Application No: LU/247/20/PL
Site Address: 57 River Road Littlehampton BN17 5DD
Description of works: Partial demolition of existing building, retention of boundary wall & street facade, partial demolition of boundary wall to incorporate new pedestrian gateway & gate, erection of 6 No. flats in 2 blocks connected by shared stair & lift core, on site parking yard for 8 No. cars & 8 No. cycles & space for communal refuse & recycling bins. This application affects the character & appearance of the Littlehampton River Road Conservation Area & is in CIL Zone 4 (Zero Rated) as flats.

Thank you for your internet representation made on 7th November 2020 which has been recorded as an objection with the comments as follows:

TITLE: PROPOSED SOUTH EAST ELEVATION

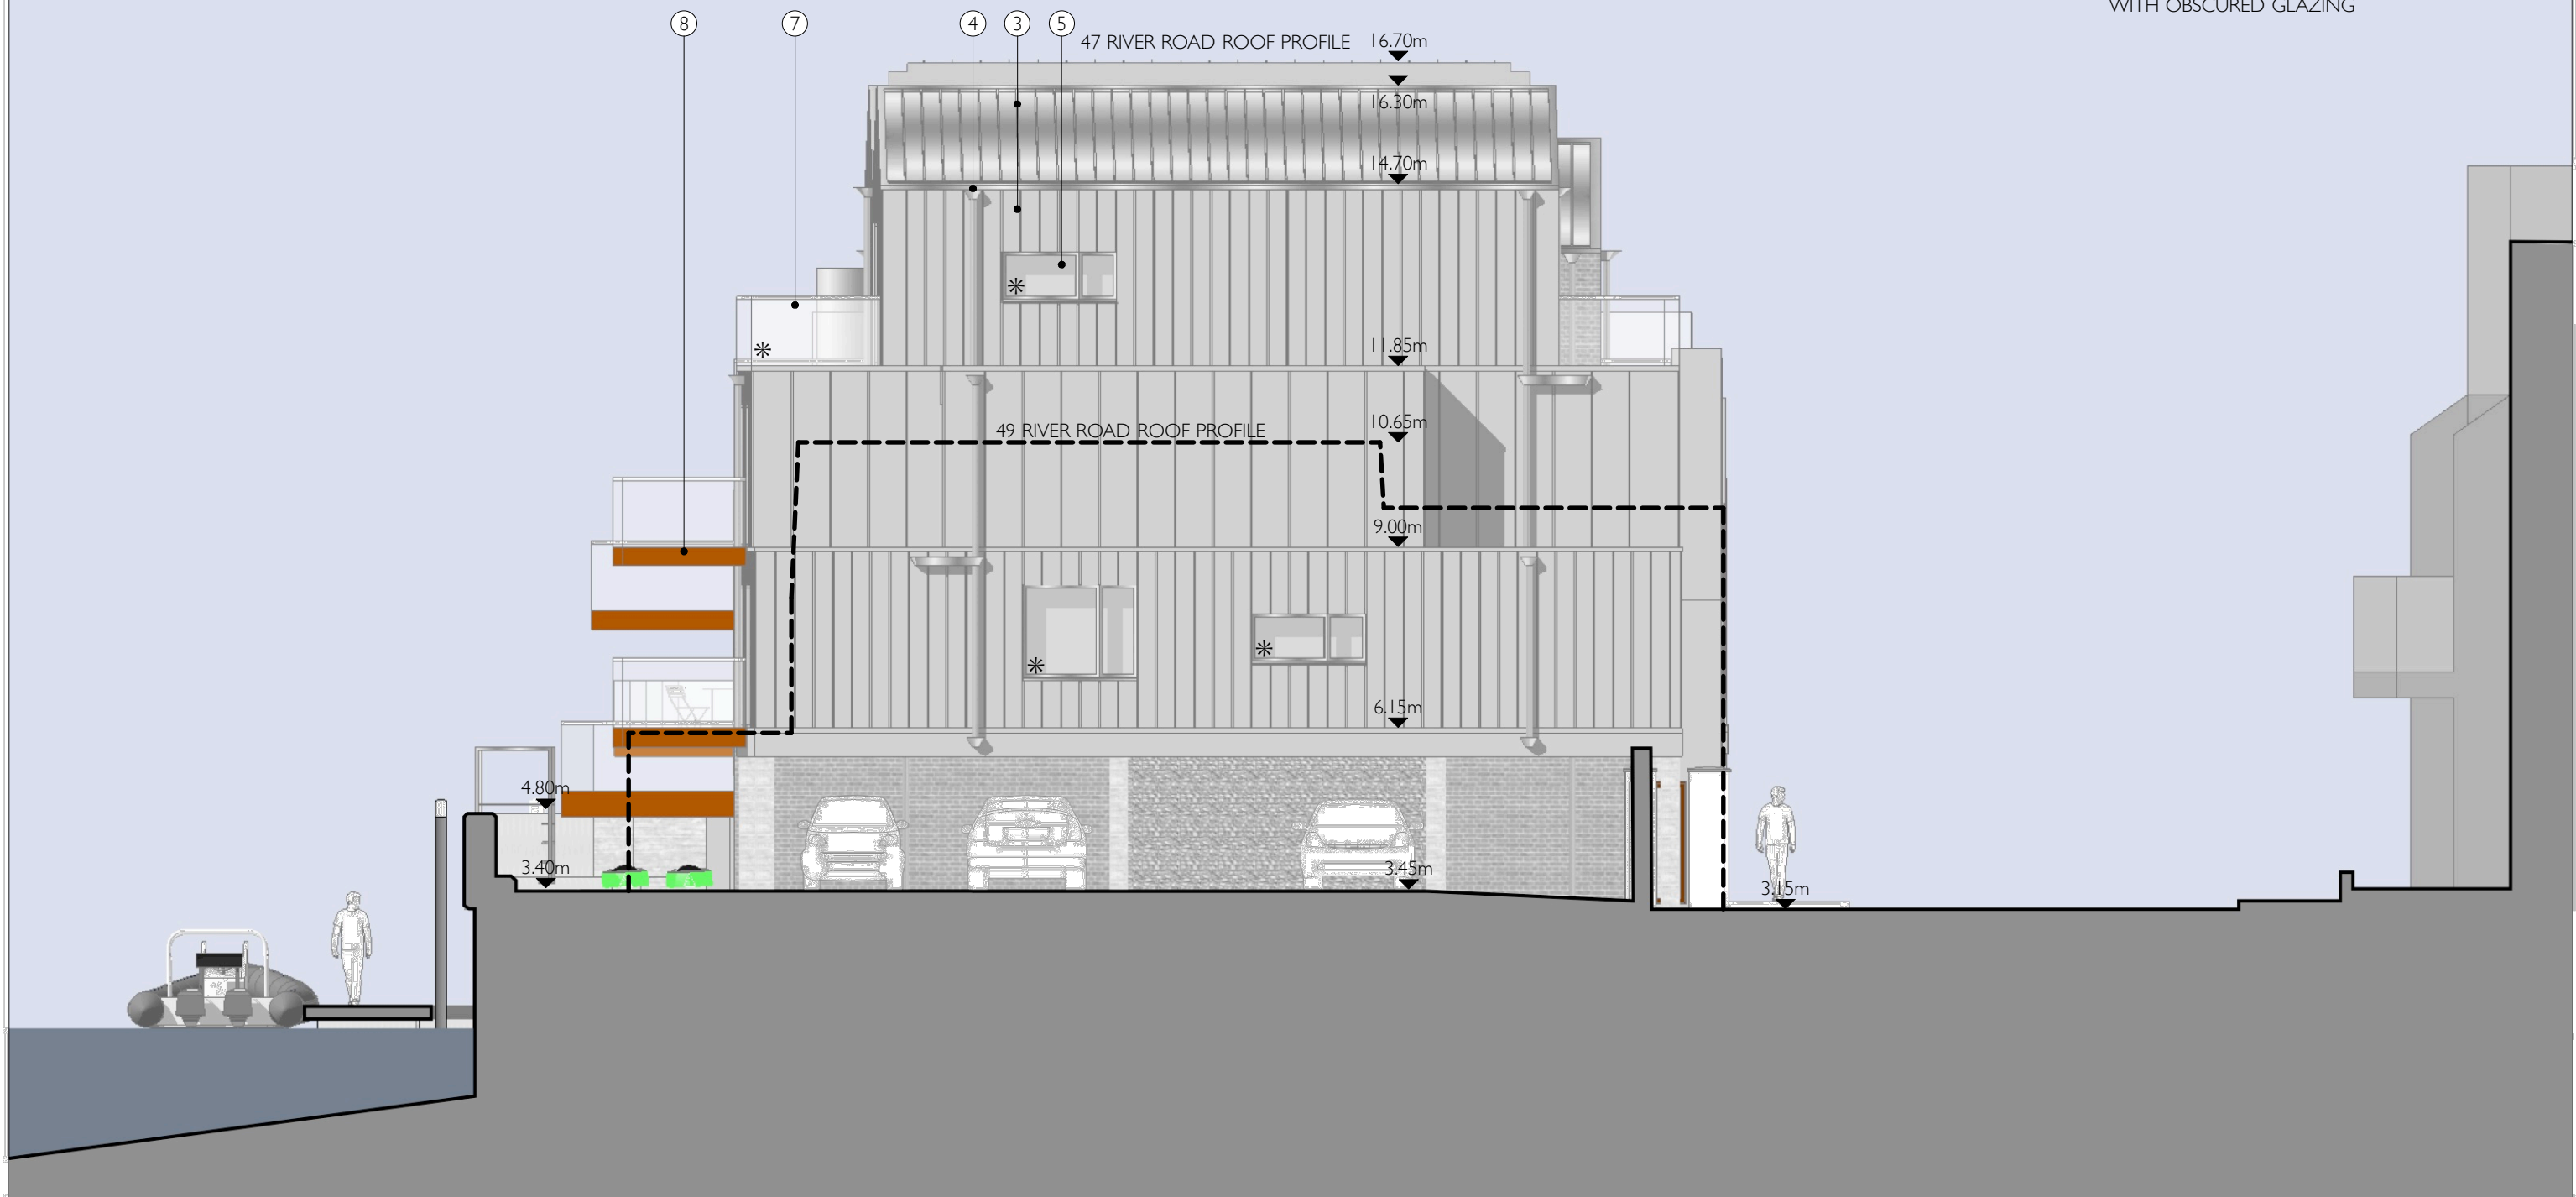
Am I to assume that , as there are no balustrade details on the south eastern elevation plan, that there will be no access to the set back flat roof areas?.

There is no detail of these shown on front or rear elevations,

Can it be clarified that there are no longer

"Upper set back amenity terraces "?
